Mama B's Southern Kitchen
330 E Stewart St.
Coats, NC 27521

The plans and specifications for the above referenced establishment were reviewed and are approved with the following comments:

Jamie Turlington, REHS
Harnett County Environmental Health
Harnett County Health Department
(910) 893-7547 ext. 6289

EQUIPMENT PLAN  
SCALE: 1/4" = 1'-0"

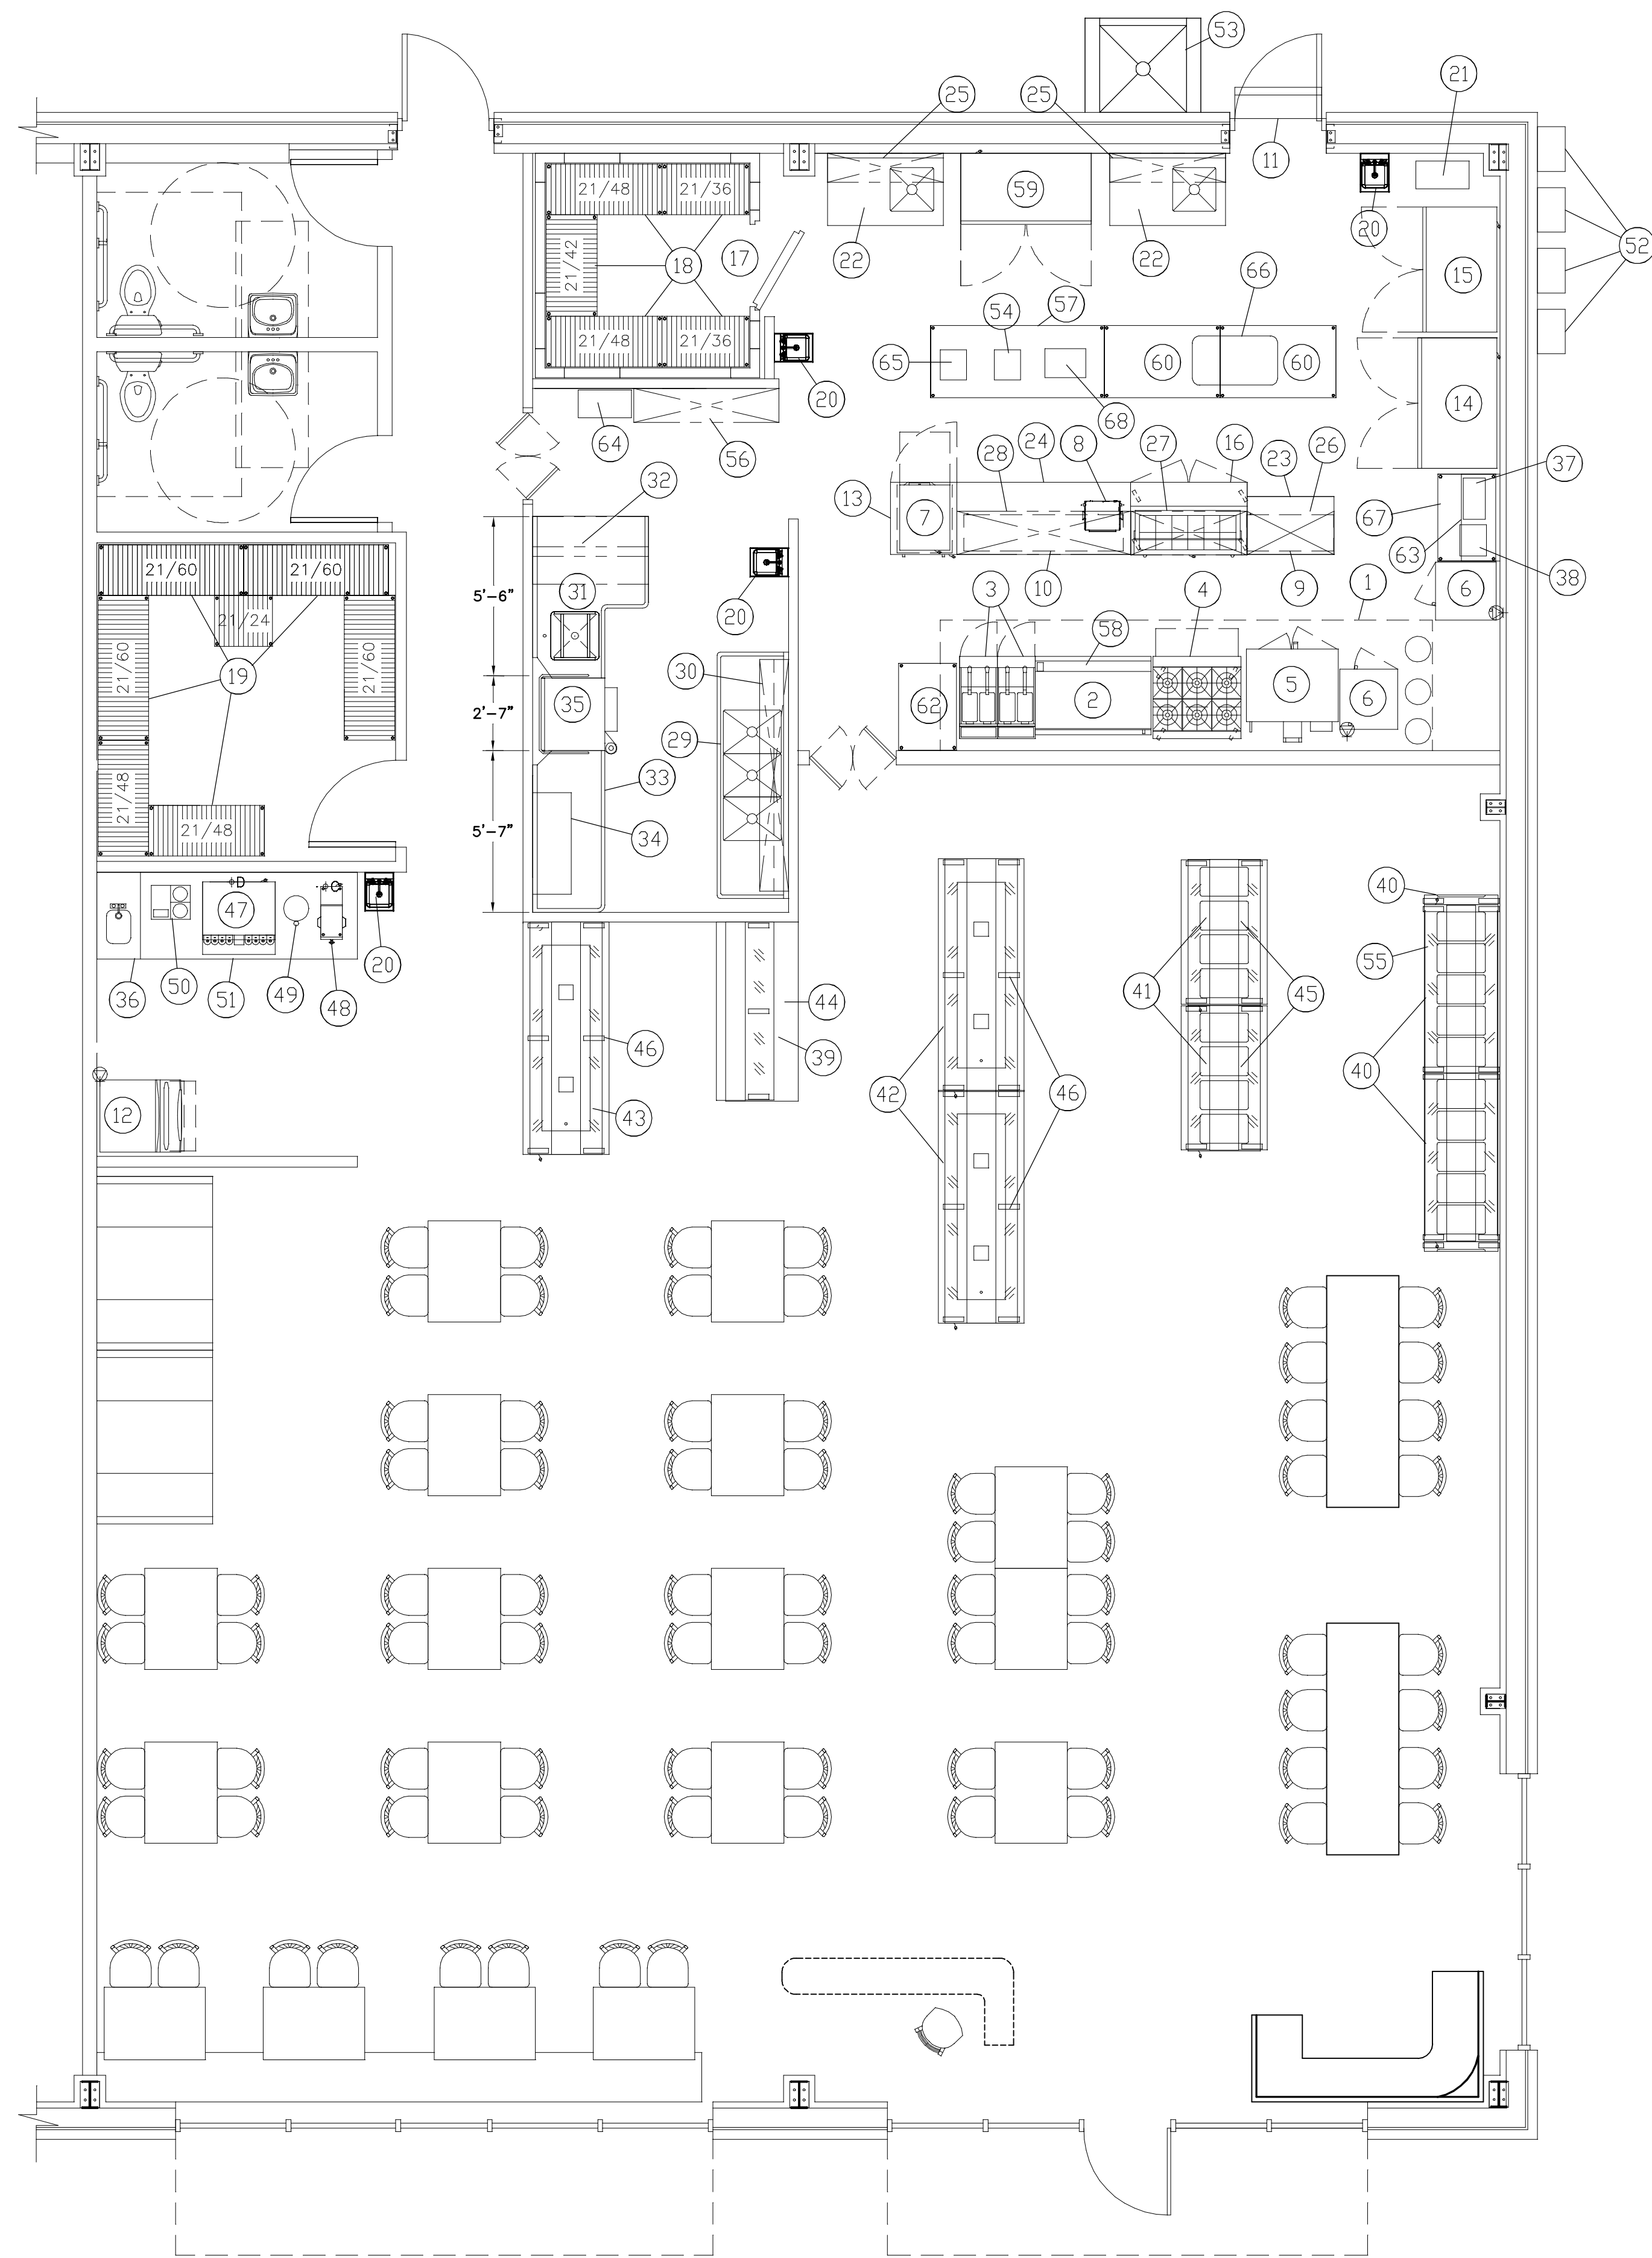
1. The revised plan submitted to Central Permitting on 12-23-24, are approved. Any changes to the plans, equipment specifications and menu must be submitted for review and approved.

2. All food equipment, shelving, counters, and cabinetry must comply with subpart 4-205 of the North Carolina Food Code and be installed as specified in Sections 4-402.11 and 4-202.12 of the Code. All used equipment must be in like new condition and meet the referenced Codes above. Used equipment will be field evaluated to ensure it meets the Code. Provide an equipment specification sheet for the unlabeled 2-door refrigerator on the revised plan. Provide a specification sheet for #36, the 36"x9" S/S beverage table with hand sink. The equipment in the far corner (nearest the wall) does not have a number or corresponding description on the equipment list. Provide information on the equipment including a specification sheet. Contact me regarding these items if you have questions.
